Planning Application Ref: A/23/18/DOC

Location: Land at Broadlees, Dappers Lane, Angmering

Description of works: Seeking approval of matters reserved by Condition imposed under **A/27/16/PL** relating to condition 19 Tree Protection Measures.

TREE PROTECTION (Plan 3A)

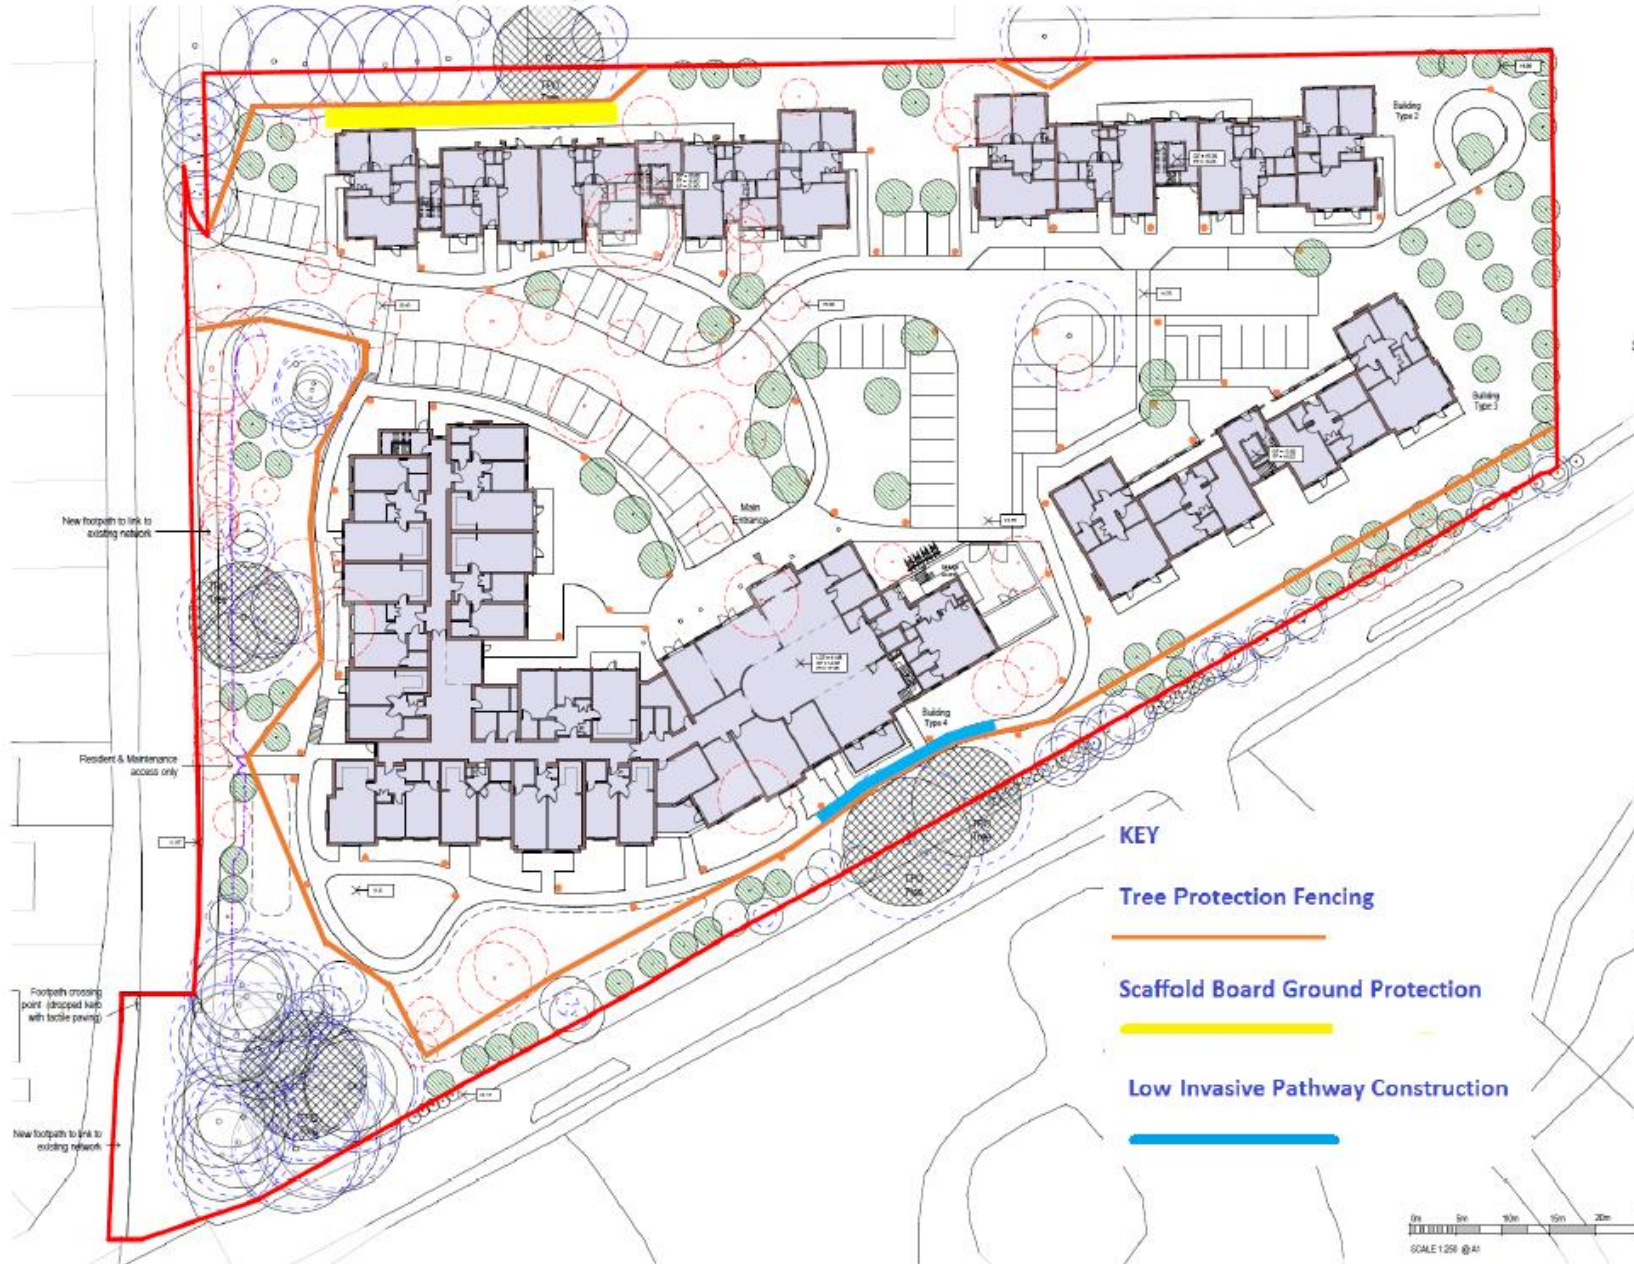
- This site is overgrown and in a wild and impenetrable state with dense vegetation surrounding many of the trees that are to be retained.
- At the present time NO vegetation clearance has taken place and NO protective fencing has been erected.

- In the absence of general vegetation clearance and erection of Protective Fencing the Condition has not been complied with and I am therefore unable to sign it off at this time.

- I note that the applicant has submitted a Tree Protection Plan Ref: Plan 3A – the measures set out on this plan are acceptable but will need to be implemented and then a Pre-Commencement Meeting can take place [at a mutually convenient time] between the applicants representative and the Arun DC Tree Officer to agree that the Protective Fencing complies with BS5837 recommendations and is 'Fit For Purpose' and that it has been erected exactly as shown on Plan 3A.
